Letter No. **D.Dis.A1/374/91**

Sub: MMDA - Planning Permission - Proposed
Construction of residential building
at Basement Floor + Ground Floor +
First Floor in Plot No.61B, Door No.35,
Kasthuribai Nagar, IInd Main Road at
T.S.No.18pt. of Kottur Village -
Approval - Regarding.

3. The approved plans are numbered as planning permit
No. **A/5245/91** and 3 copies/~~sets~~ of the same along with the
copy of the planning permit are enclosed herewith for taking
further action in this regard.

3' DIA WELL SECTION
 Planning Permit No. A/245/91
APPROVED
 SUBJECT TO THE CONDITIONS IN
 THIS OFFICE LETTER.
 No. A/245/91 Date 8.3.91
 FOR MEMBER SECRETARY
 MADRAS METROPOLITAN
 DEVELOPMENT AUTHORITY
 MADRAS - 600 008

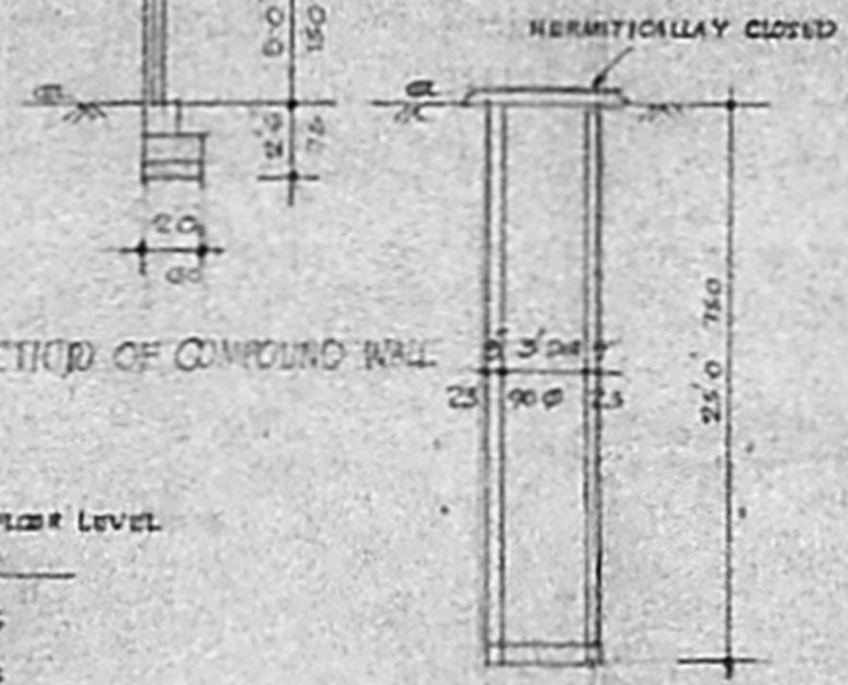
- i) 'in the Open space within the site to the extent
feasible trees be planted and the existing trees
preserved'
- ii) 'it was requested to ensure that the plans for
the new buildings will incorporate the approved
designs for mosquito-proof overhead tanks and
wells'
- iii) 'improvement charge, open space reservation
charge and other charges as applicant'.

BASEMENT FLOOR

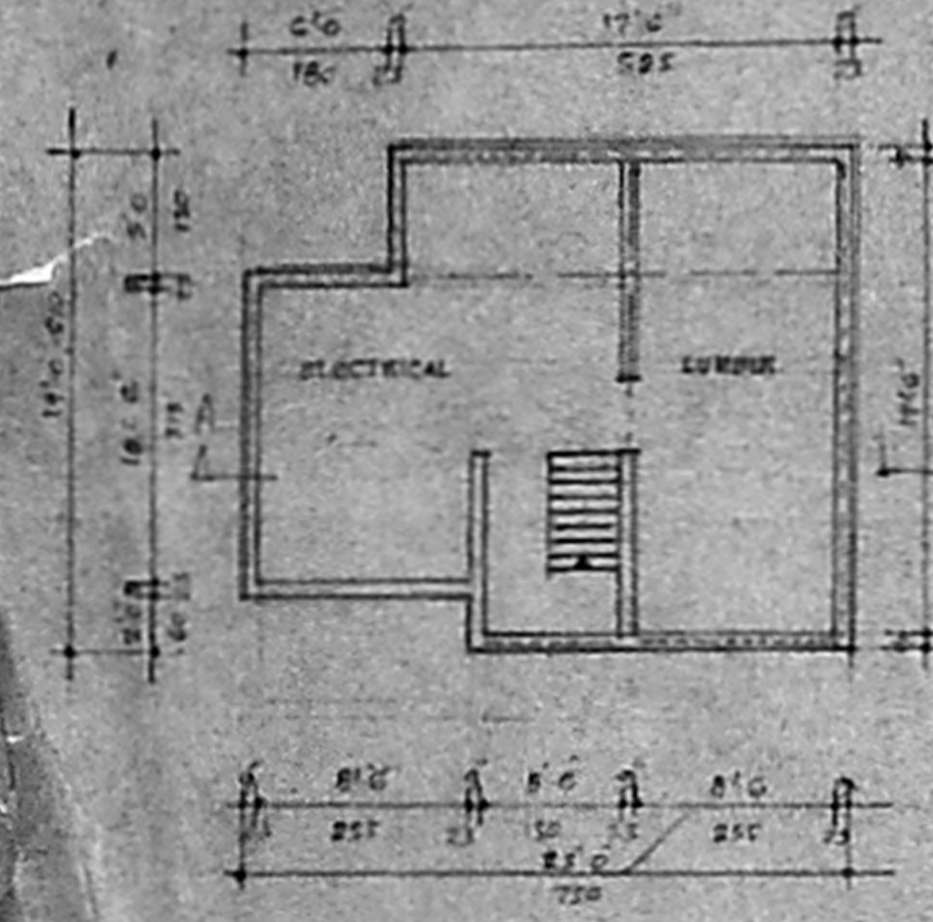
**** (iv) The basement floor should satisfy
the Building Rules requirement.**
